**CITY OF PORTLAND, MAINE  
DEVELOPMENT REVIEW APPLICATION  
PLANNING DEPARTMENT PROCESSING FORM**

**Single Family Home**

RE: Application for Single Family Dwelling, 55 Mallilly Road

Thank you for your application for the single family home at 55 Mallilly Road. Upon review of the site plan, the City has the following comments:

SITE PLAN FOR
PROPOSED HABITAT FOR
HUMANITY DWELLING ON
55 MALILLY ROAD

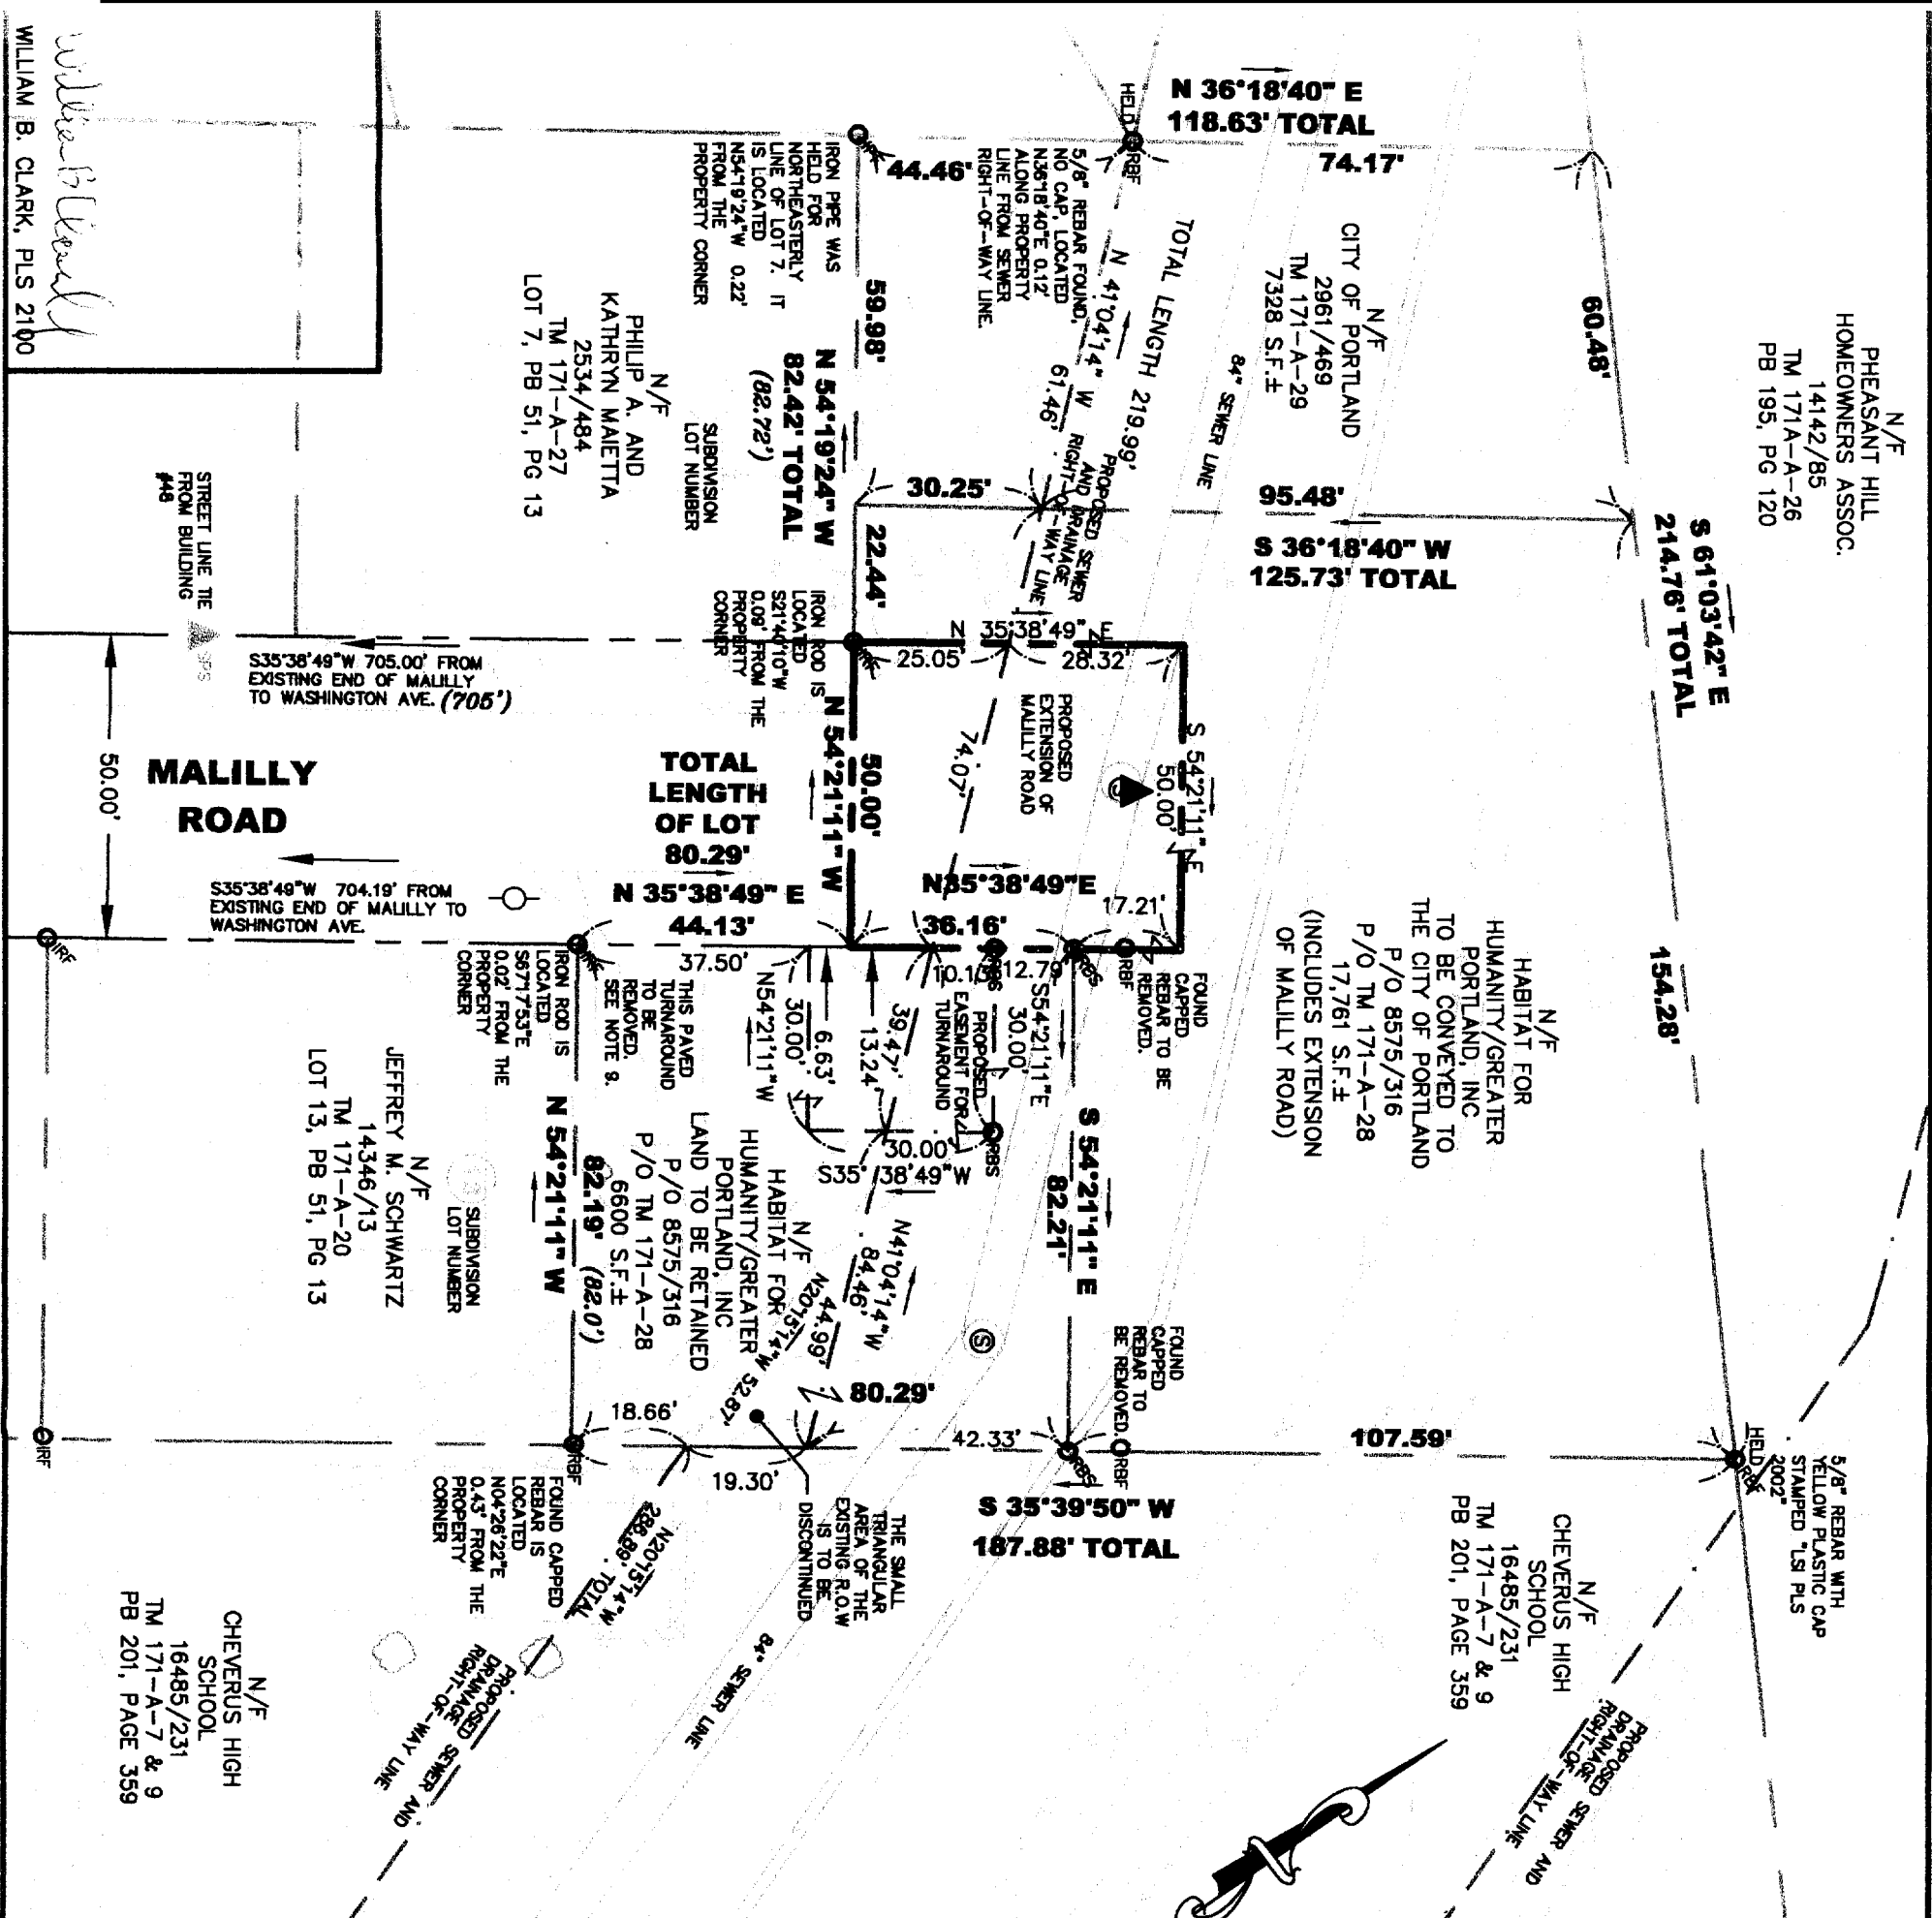
- c.
    - i. If tree clearing and/or soil disturbance is to occur within 75' from the most upland edge of Fall Brook, additional permitting is required by the Maine Department of Environmental Protection (permit by rule).

- ii. Please provide more detail with regard to Fall Brook's channel as it nears the property.
  - d. Please show the proposed topography/final grading

- e. The buildout of this lot as shown will result in the loss of a turnaround area for the City. The City requests that this application accommodate the City by providing a turnaround area and easement that is satisfactory to the Public Works Department.
